**From:** Paul Troop <pault@gclaw.co.uk>  
**Sent:** 30 March 2023 10:22  
**To:** Suzanne Taylor  
**Cc:** White, Joy - Oxfordshire County Council; george@bicesterbug.org  
**Subject:** Hawkwell 21/04275/OUT  
**Attachments:** 20230329a Bucknell Junction.jpg

### Hawkwell 21/04275/OUT

I note that Bicester Bike Users' Group has not yet been formally consulted on the proposed junction at Bucknell Road, but due to the importance of this issue to walking and cycling in Bicester, I thought I would write to raise some major concerns with the initial concept.

TITLE:
PROPOSED SIGNALISED JUNCTION

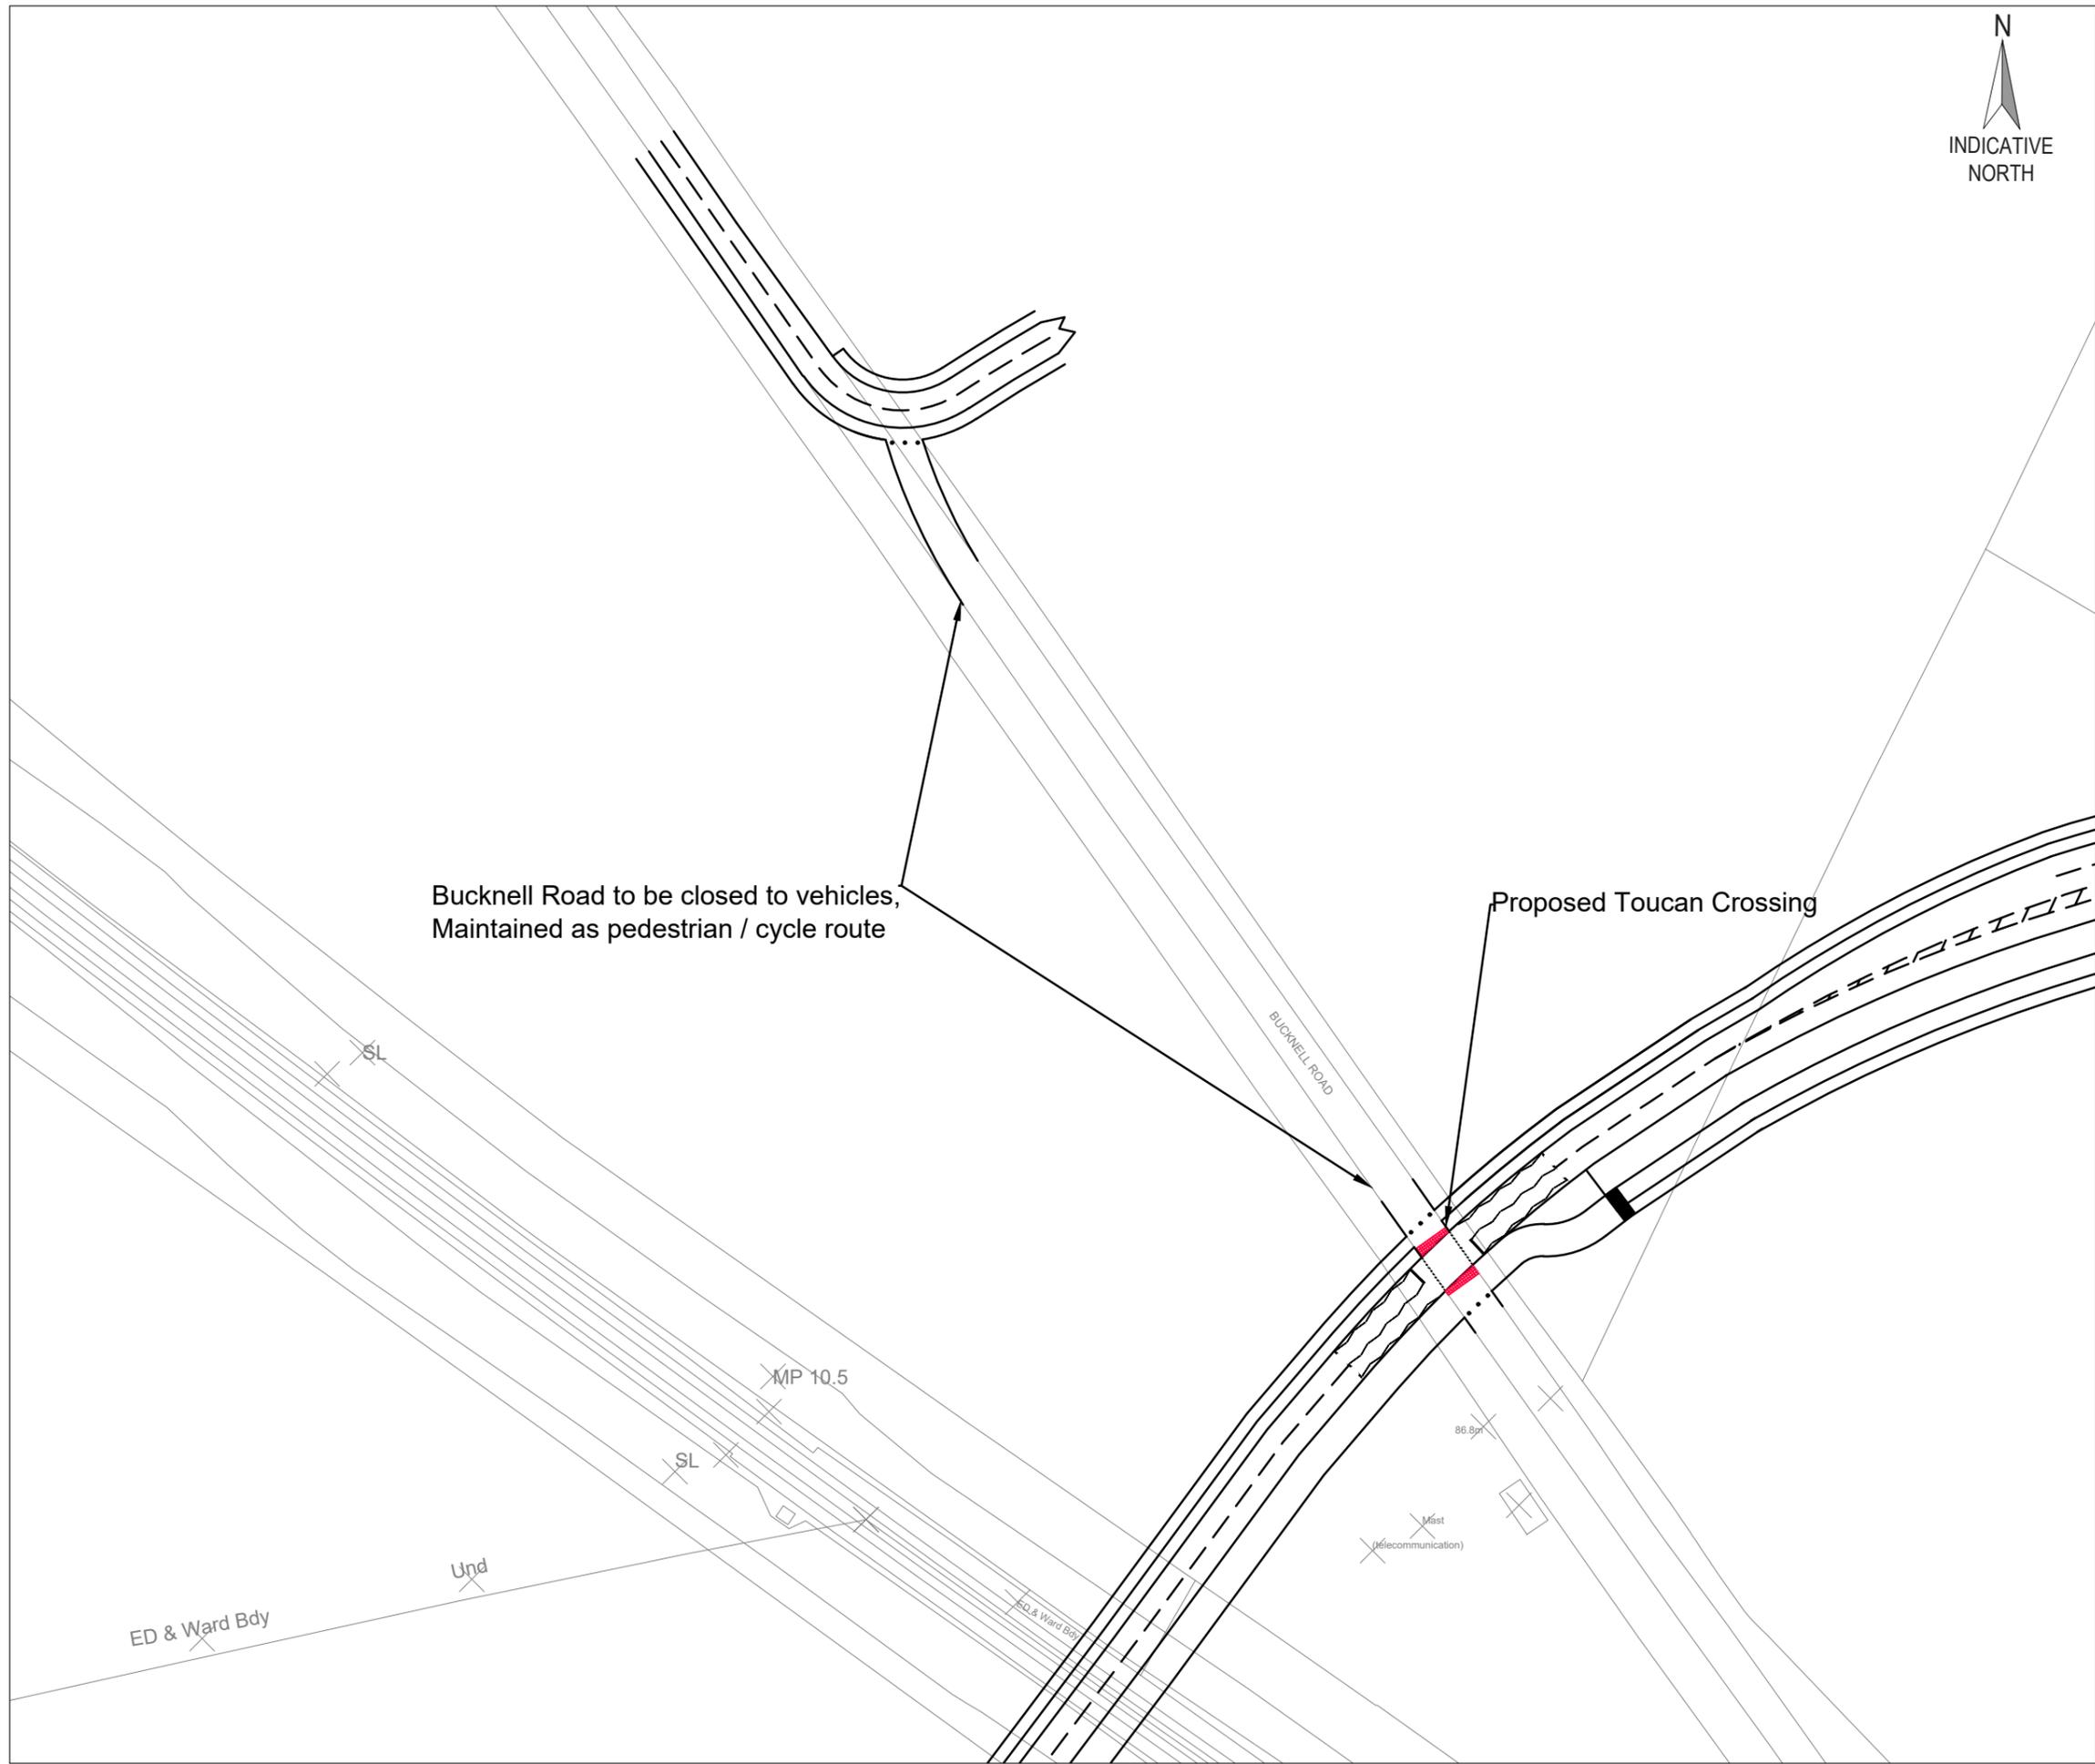
This initial proposal has no provision whatsoever for cycling and poor provision for walking. As such, it does not meet with current Bicester highways policies and there must therefore be a serious question about the feasibility of the application.

- Single phase shared crossings are provided on all junction arms.
- Segregated provision and buffers are provided where space permits, shared provision otherwise.
- A 3.5m shared path is provided on the eastern side of the Bucknell Road south.
- Shared paths are provided on both north and south sides of the A4095 west.
- Buffers are provided on the western side of the Bucknell Road south and the southern side of the A4095.
- A continuous footway is provided over the key link to the bridleway connection on the western side of the A4095.
- A parallel crossing is provided rather than an uncontrolled crossing.
